Re: 1039 Riverside St. (051694 331 A001)

I have completed the review of Permit # 051694 and need the following:

**A-1**

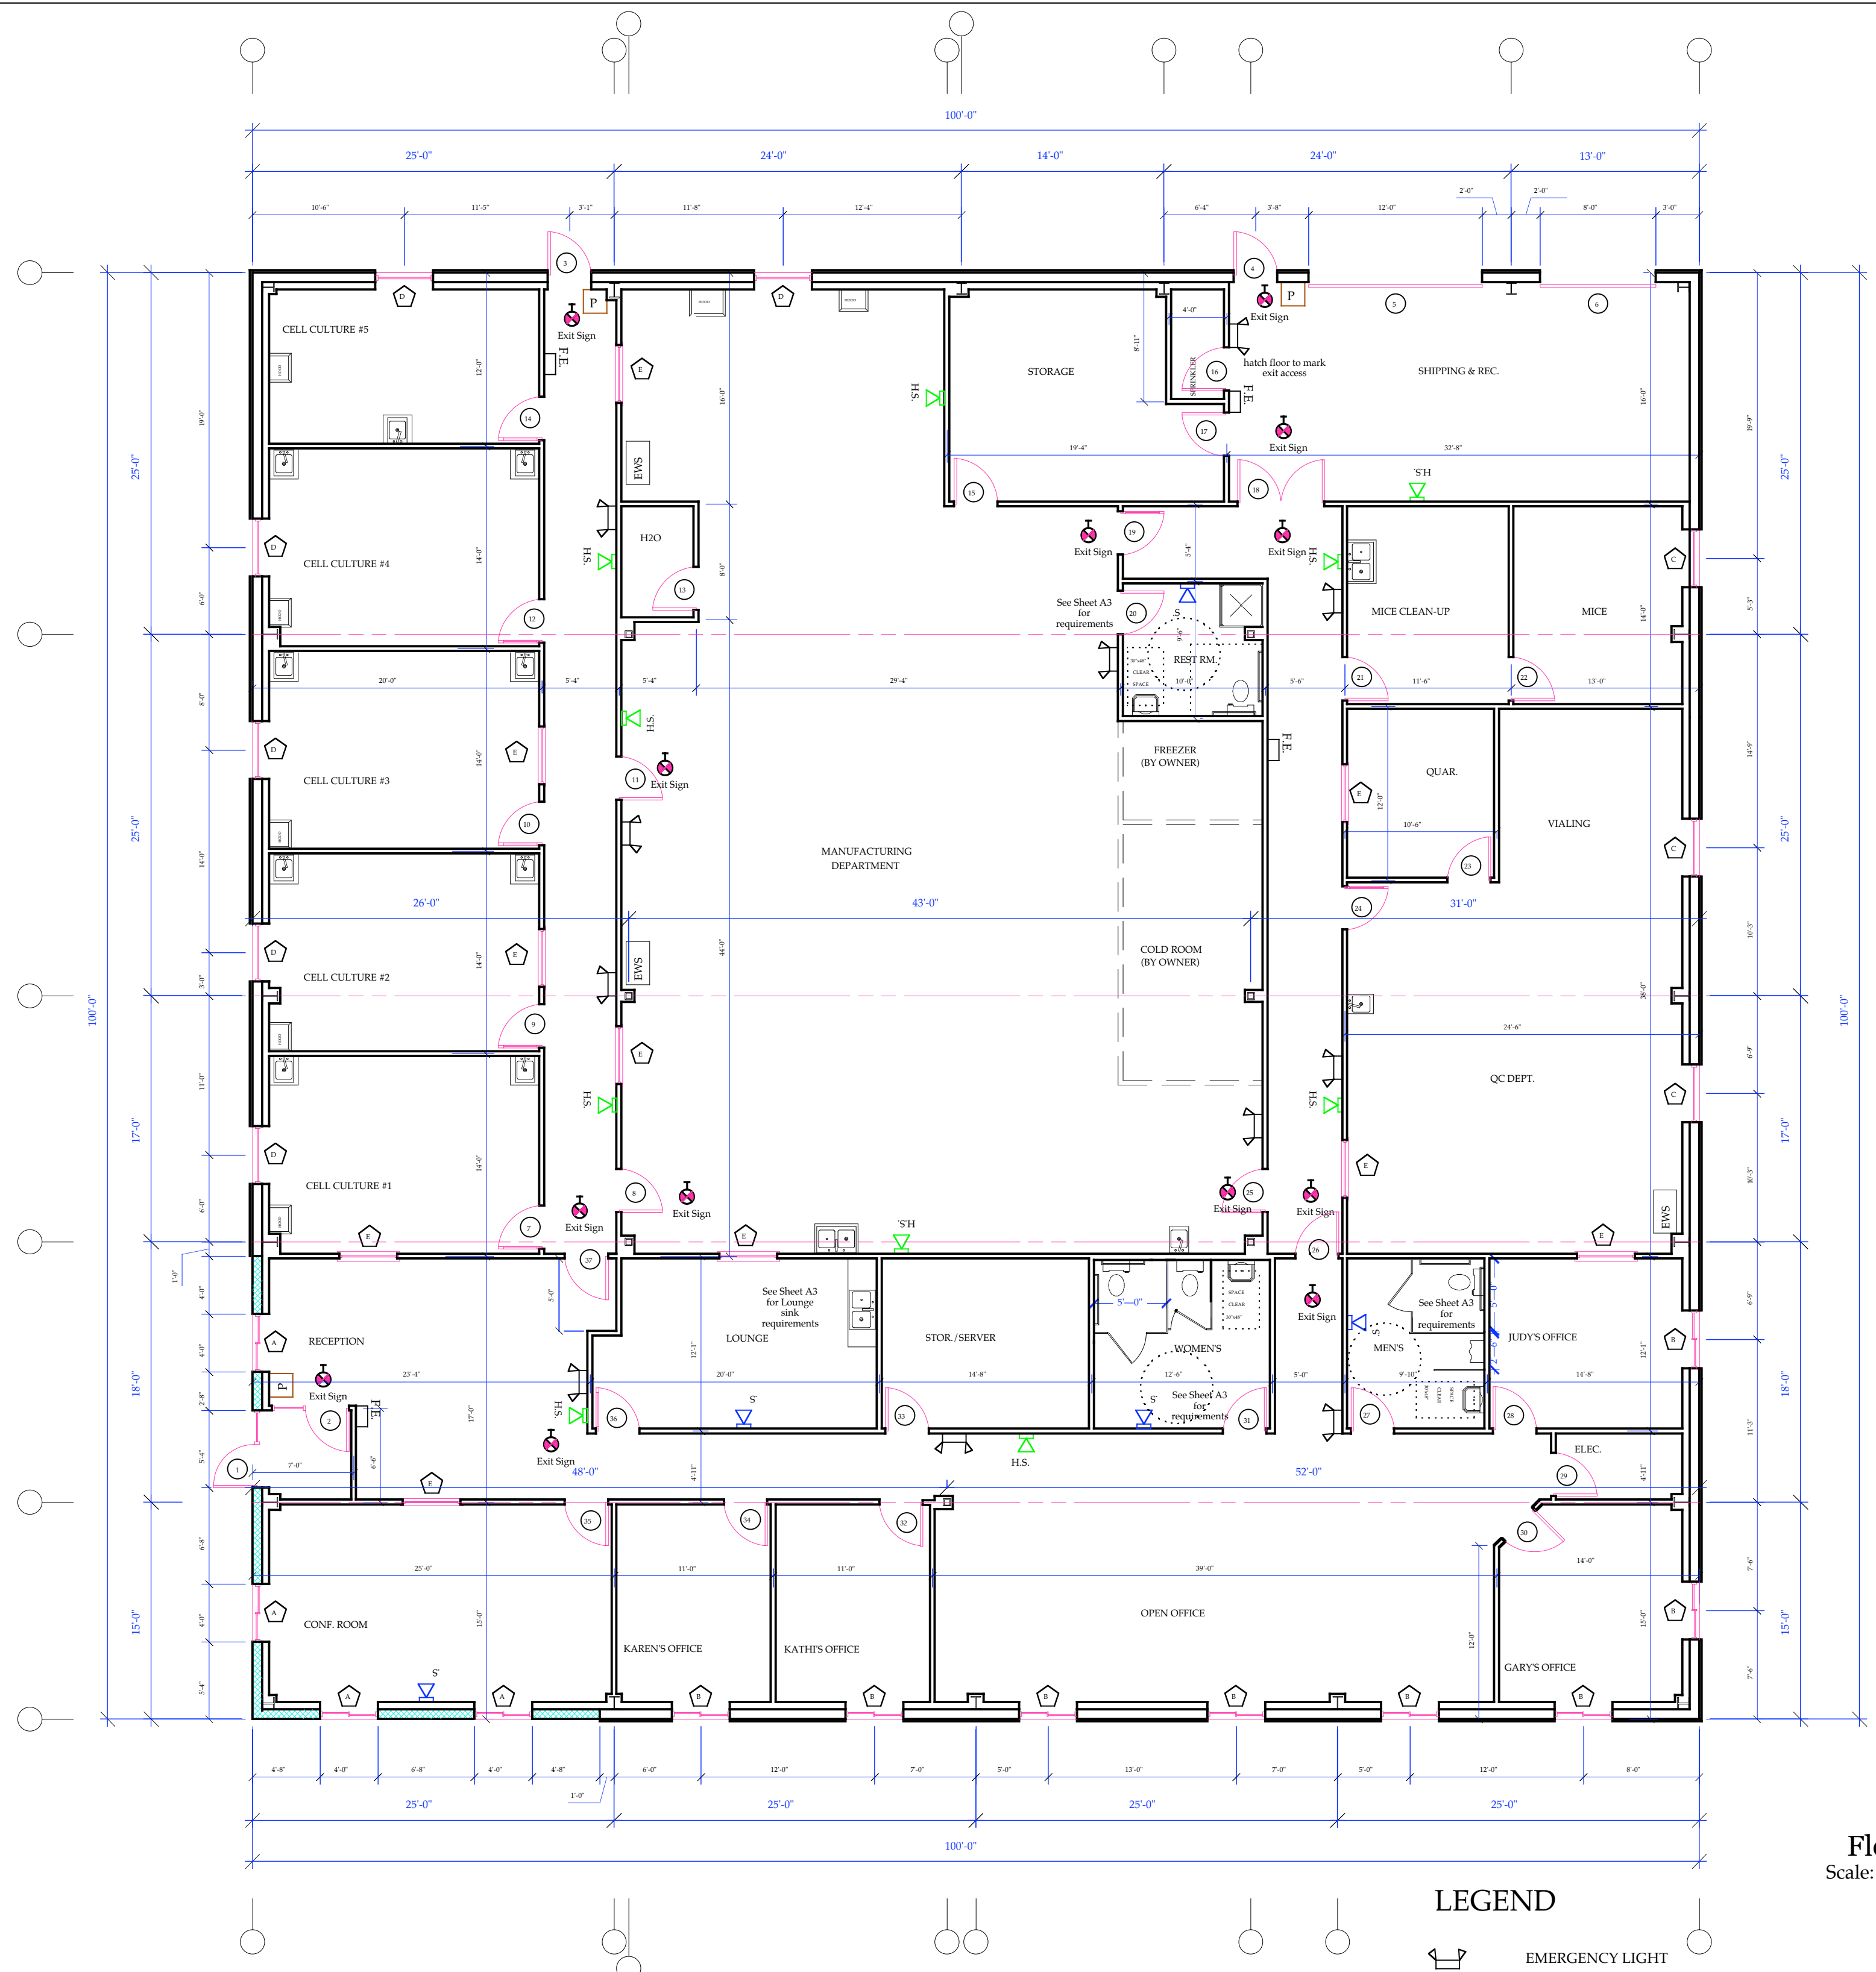
- 1) COMCheck Energy Conservation compliance Report.
- 2) Information detailing interior finishes and establishing compliance with Chapter 8 of the 2003 IBC.
- 3) HVAC, Plumbing and Electrical plans created by a licensed engineer.
- 4) Door 1 and the glazing panel next to it need to be class II Safety Glazing.
- 5) All doors are shown as landing at grade. If this is not the case, code compliant stair plans must be submitted and approved.
- 6) The Architecturals did not have any details, really none! Except the simple wall cross section. The general contractor is disallowed by law from doing design work, so the architect needs to provide detail work for the complete construction.
